**HERITAGE ADDENDUM  
(SD 17\_8665)**

**MERCANTILE HOTEL**

**25-27 GEORGE STREET,  
THE ROCKS 2000**

Urbis has been engaged by Welsh & Major to prepare the following heritage addendum pertinent to the refurbishment works and rooftop terrace proposed at the Mercantile Hotel, The Rocks (SSD 17\_8665).

Drawing No.
SSDA 502

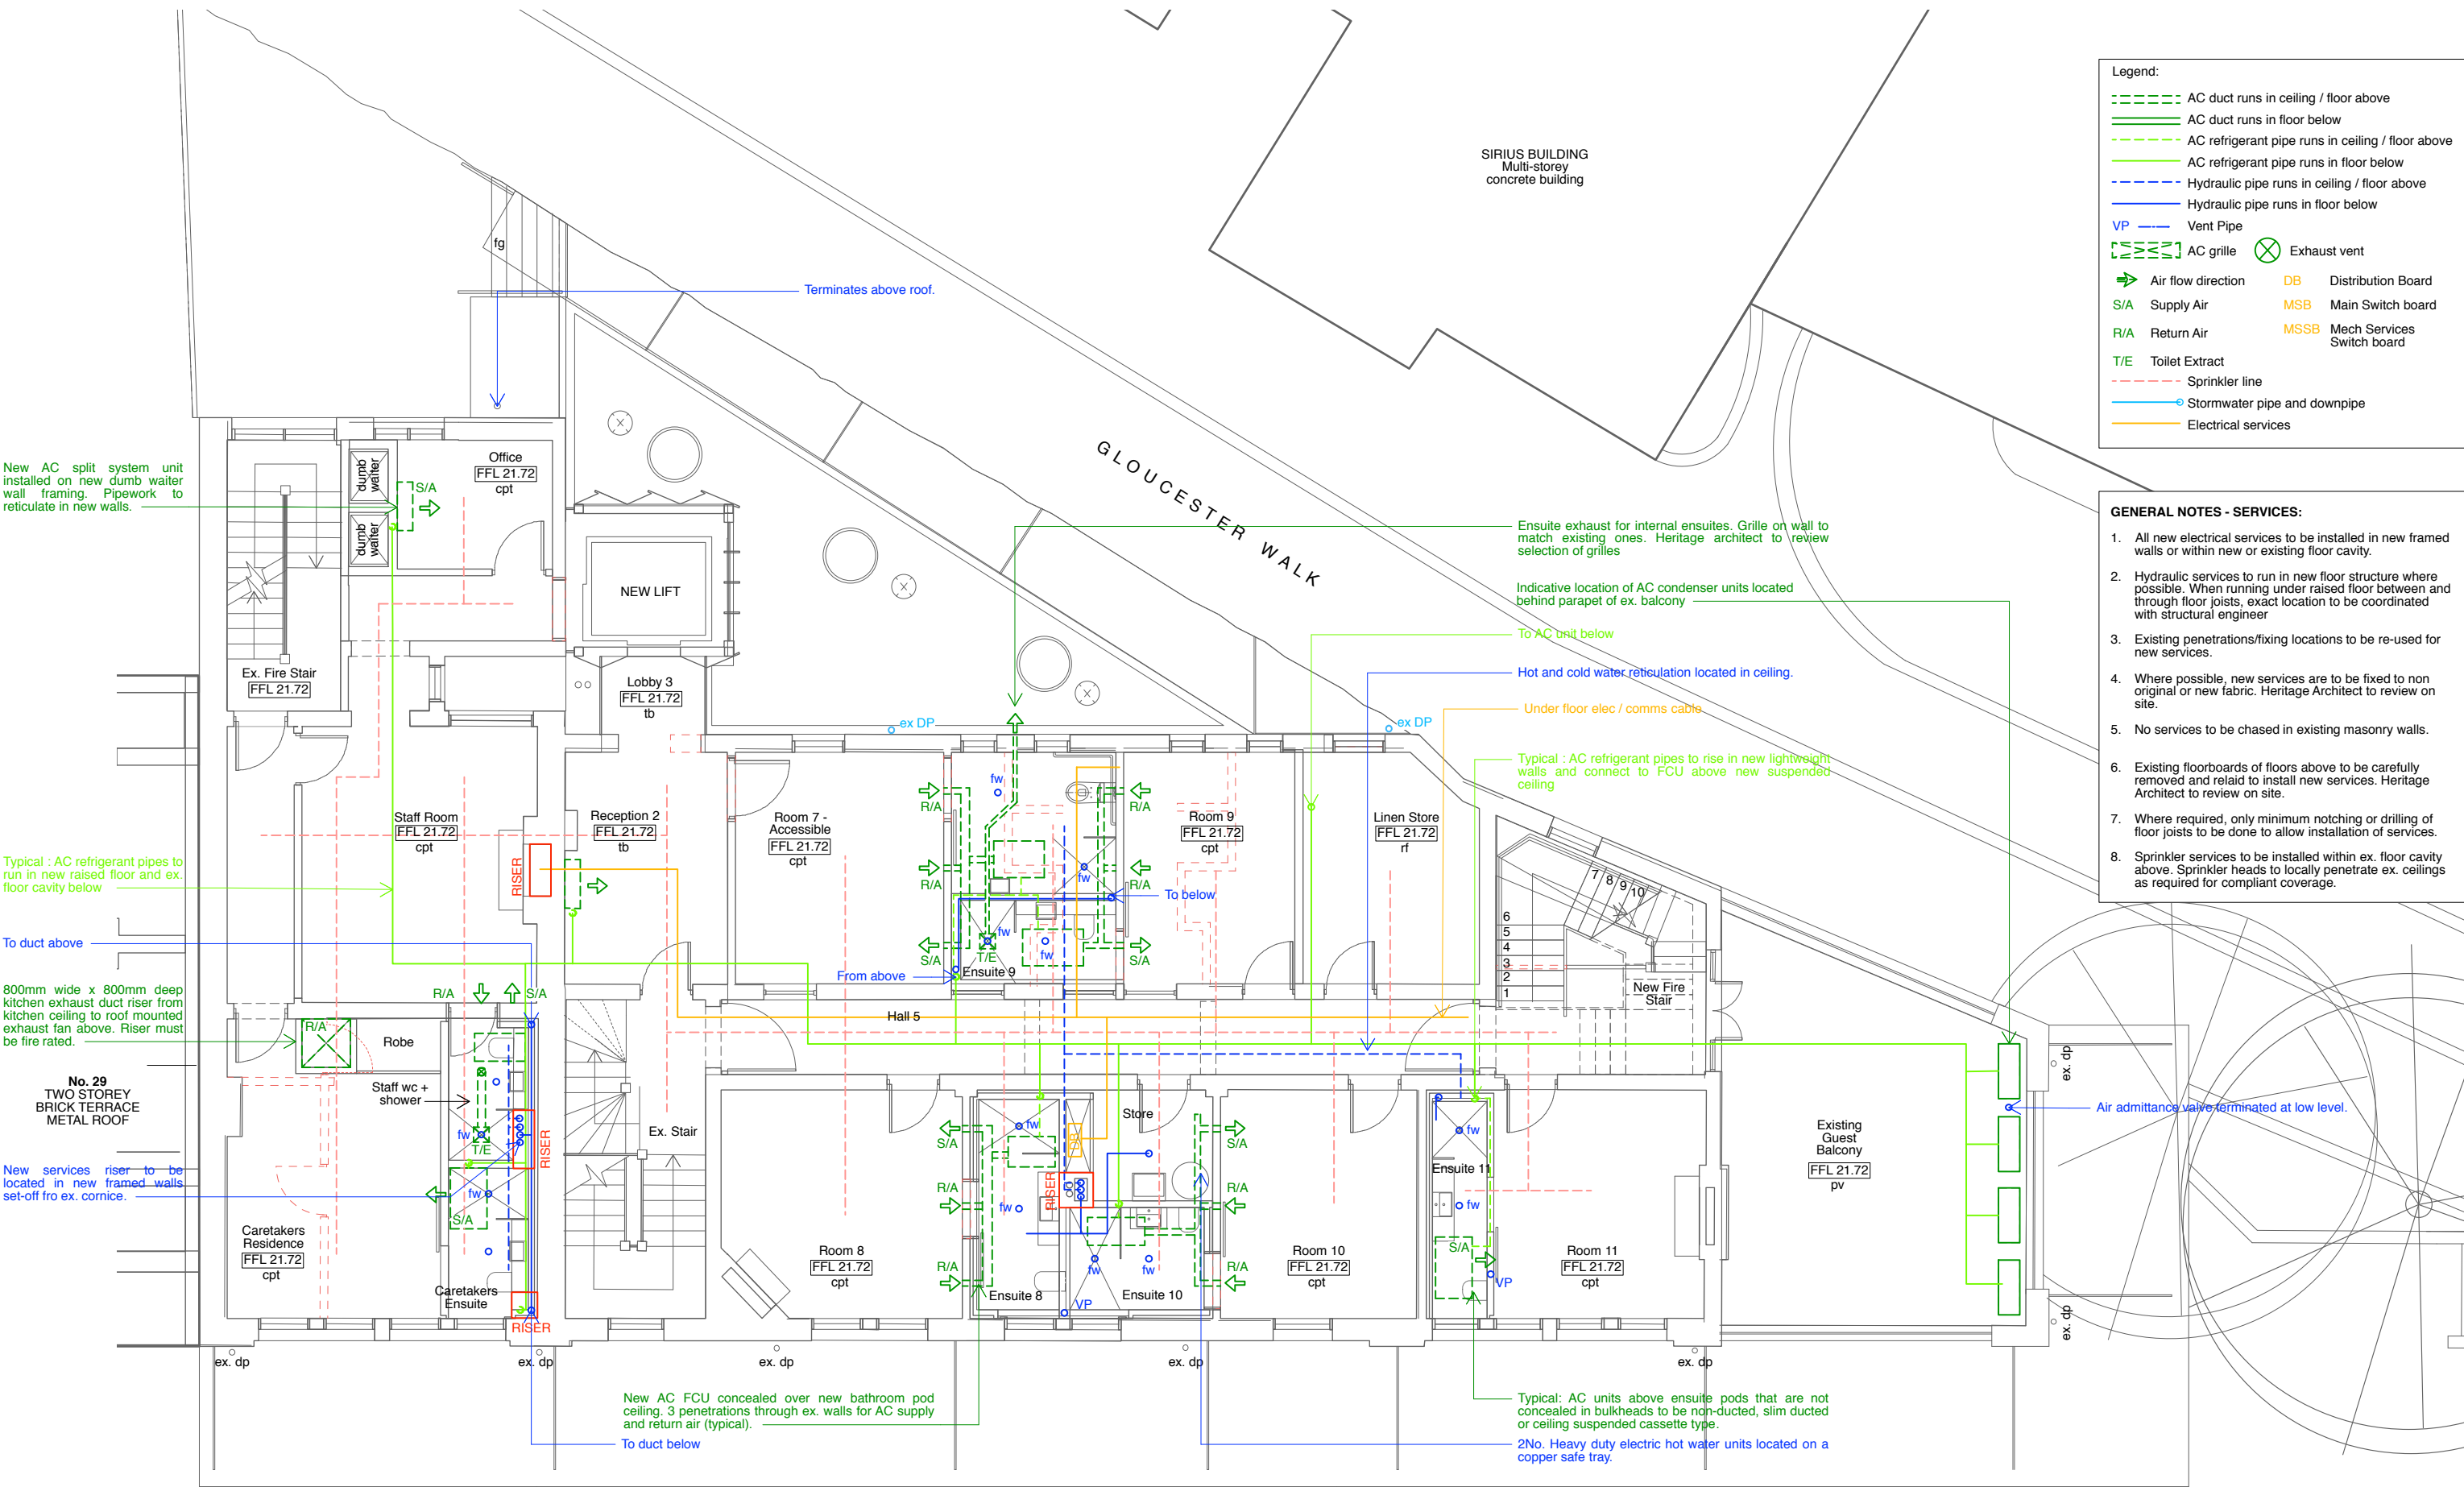
*Details have not been submitted, and only an indicative location and size of the exhaust is shown on the submitted drawings. Details of new kitchen mechanical exhaust and associated ducting should be developed in consultation with the applicant's heritage consultant with the aim of minimising visual and physical heritage impacts. These details should be submitted for consideration prior to determination of this application.*

*Provide further information in relation to the provision of services, including mechanical, electrical and hydraulic, stormwater drainage, communications and data fixings, fire separation and acoustic separation measures, new plumbing and mechanical exhausts, in order to determine the extent of heritage impacts. This shall include information on removal of existing services and provision of proposed services, including any proposed fire upgrades and services being introduced onto the roof.*

- Kitchens and bathrooms and associated services and exhausts and vents;
- Air conditioning upgrades to the building, duct runs, risers, plant etc;
- Fire upgrades – does not discuss penetrations through fabric, the significance of fabric, or the impacts; and
- Additional services elements being introduced onto the roof – exhaust, mechanical plant including air conditioning, vents and flues etc, and their location and potential visual and heritage impacts from these works.

The Heritage Impact Statement advises that timber floor boards will be lifted to install services. This solution is reasonable only when it is used sparingly. There is concern that the extensive reticulation of new services will adversely affect the floors particularly when the floors feature old tongue and groove boards which are likely to split when lifted. Therefore, the extent of opening up services work affecting the floors should be shown on the general arrangement plans.

It is understood that all new electrical services would be installed in new framed walls or within existing or new floor cavities and risers as shown on the drawings. As such, it is considered that the installation of updated electrical and data services would be acceptable from a heritage perspective, would require minimal intervention into heritage fabric and would in no way diminish the heritage significance of the site, surrounding heritage items or heritage conservation areas.

As part of the upgraded amenities new mechanical exhausts would be installed to service the proposed bathrooms. The exhaust would be discharged through the wall through localised penetrations. A grille would be installed to match the style of extant grilles. The selection of the proposed grille would be determined in consultation with the designated heritage consultant. The proposed interventions and visual impact of the installation of mechanical services in relation to the updating of the bathroom amenities has been assessed as minor and acceptable. The minor impacts are offset by the positive impact of the updates in allowing for the continued use of the site as a pub and hotel offering, when many of the historic pubs in the locality have lost their accommodation offering. It is understood that in order to facilitate the ongoing use of the site, modifications are required in order to update the site in accordance with the expectations of contemporary patrons.
